**From:** Dan Suggs  
**Sent:** Tuesday, September 30, 2025 4:29 PM  
**To:** Ian Garrity; Josh Pozzobon; mcn.ellensburg@gmail.com  
**Cc:** Jamey Ayling; Ellie Myers  
**Subject:** RE: 1151 Wapiti Drive OOS plan

Before I send the variance out for public notice, I want to confirm that the proposed location of the septic system and drain field complies with Public Health standards. I've cc'd Dan for his input, as well as Mark Nelson, who designed the original OSS.

SITE PLAN

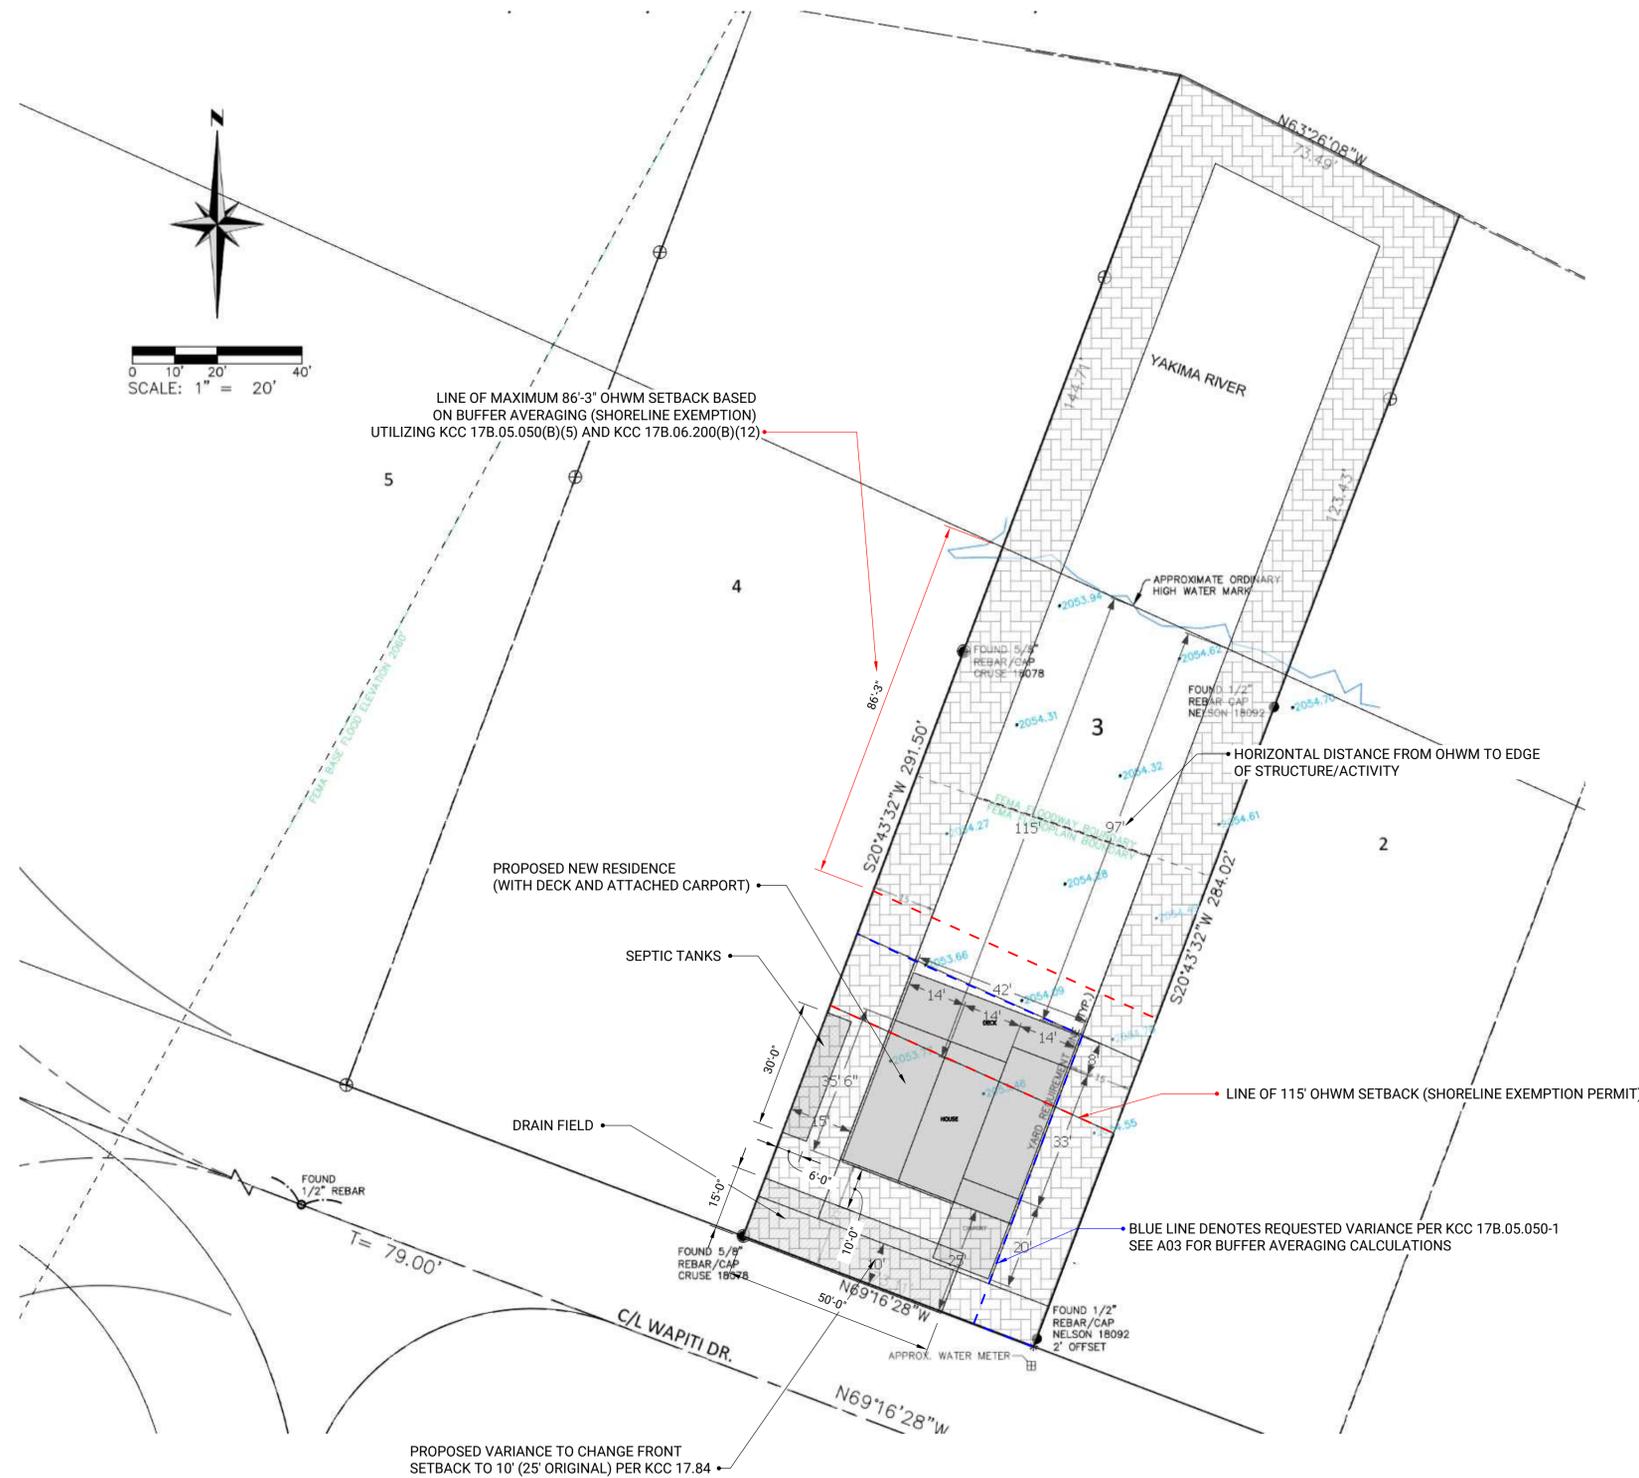
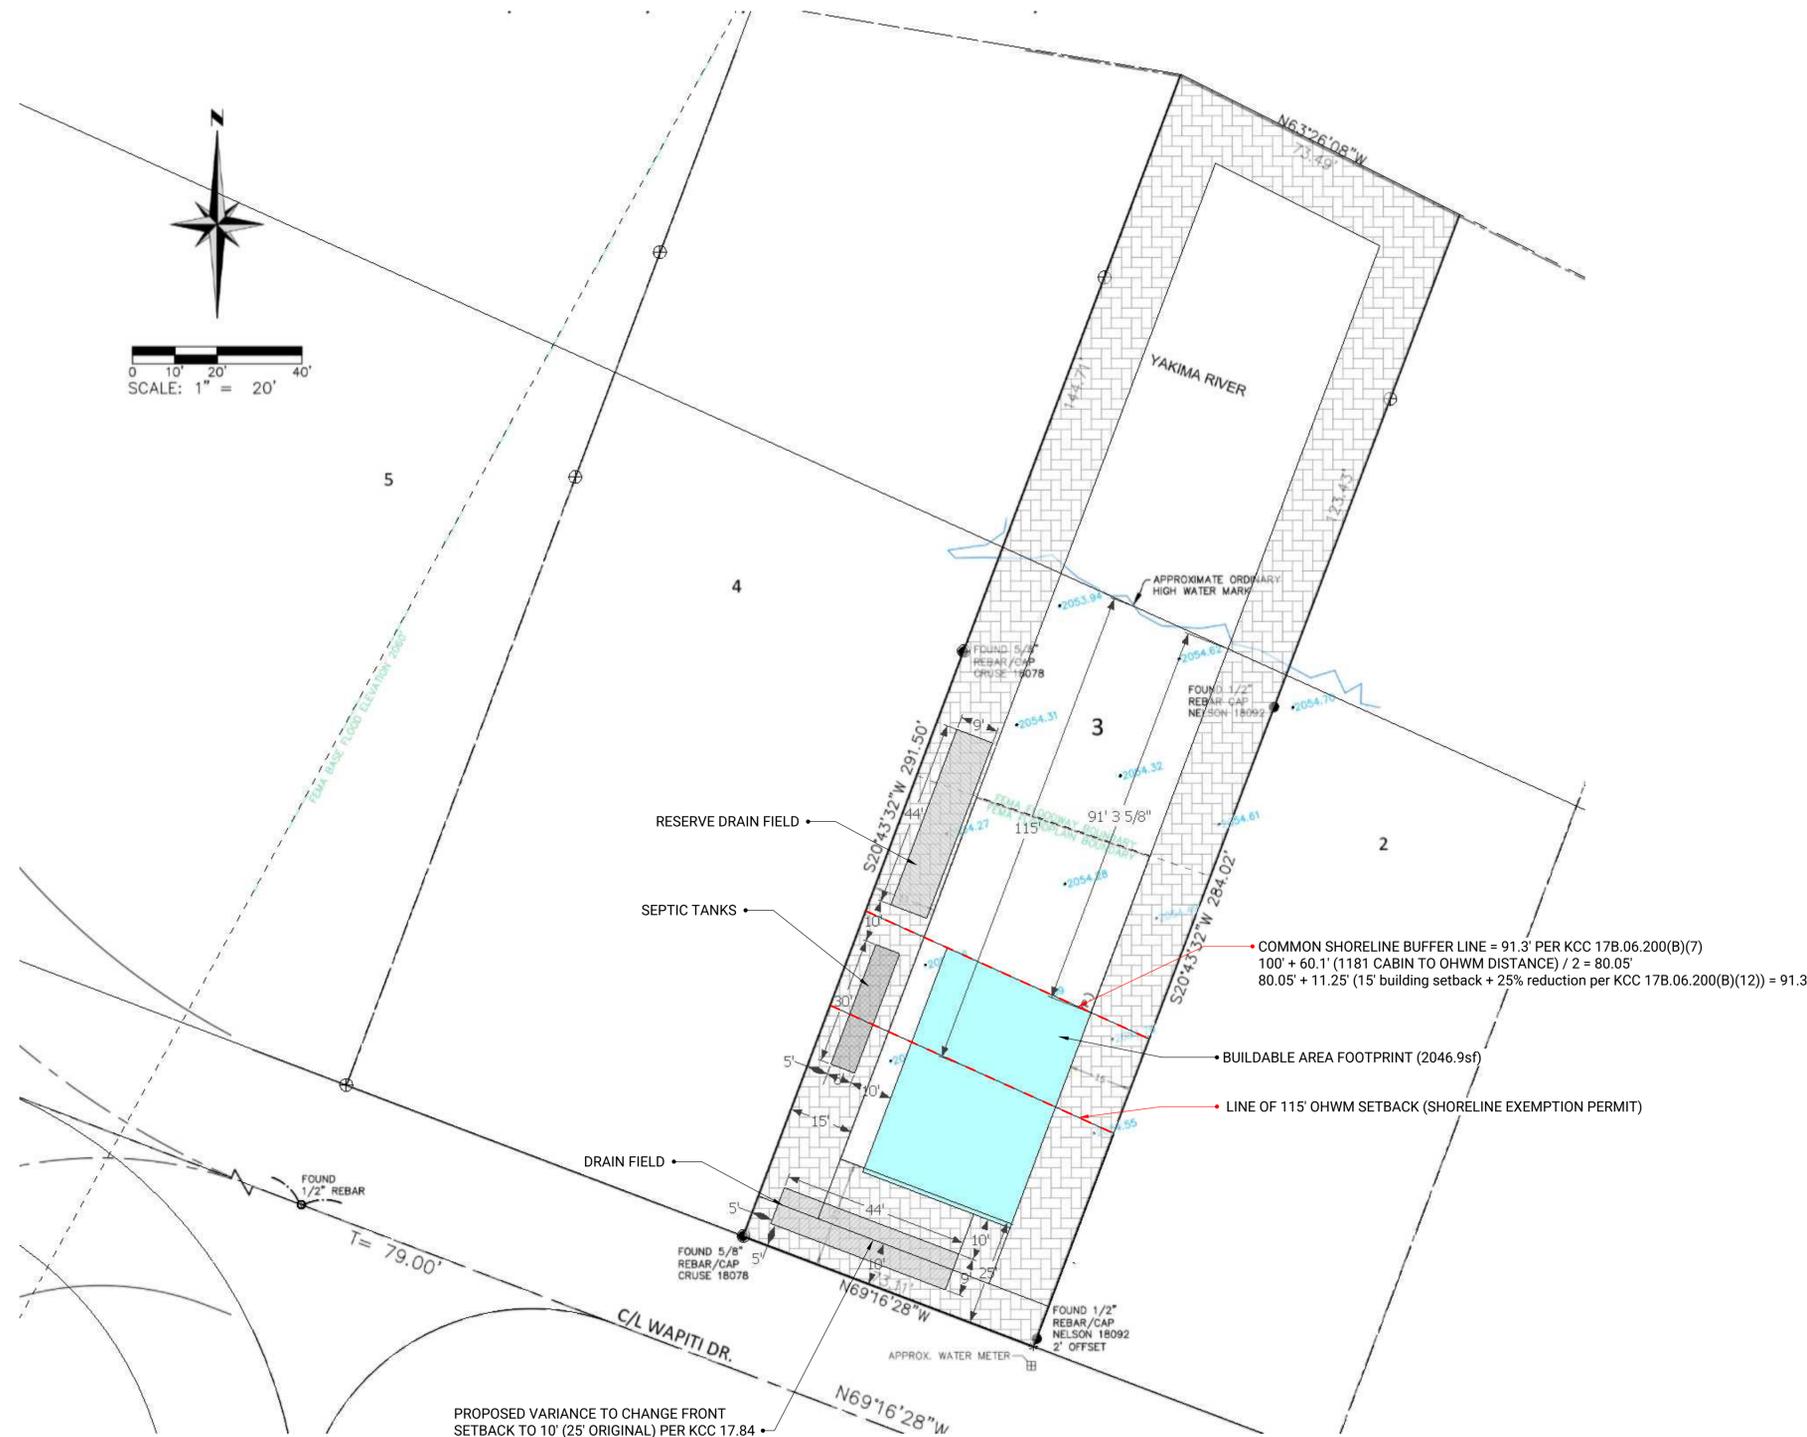
I have attached a copy of the OSS permit and design we have issued for this parcel. The building site plan does not provide enough space for the planned OSS. If you need to revise your OSS plans you should consult with your designer.

Once you receive feedback from Dan, please revise the site plan accordingly. After that, we should be ready to proceed with the notice. Ideally, if the timing works out, this will align with the shoreline exemption management and mitigation report.
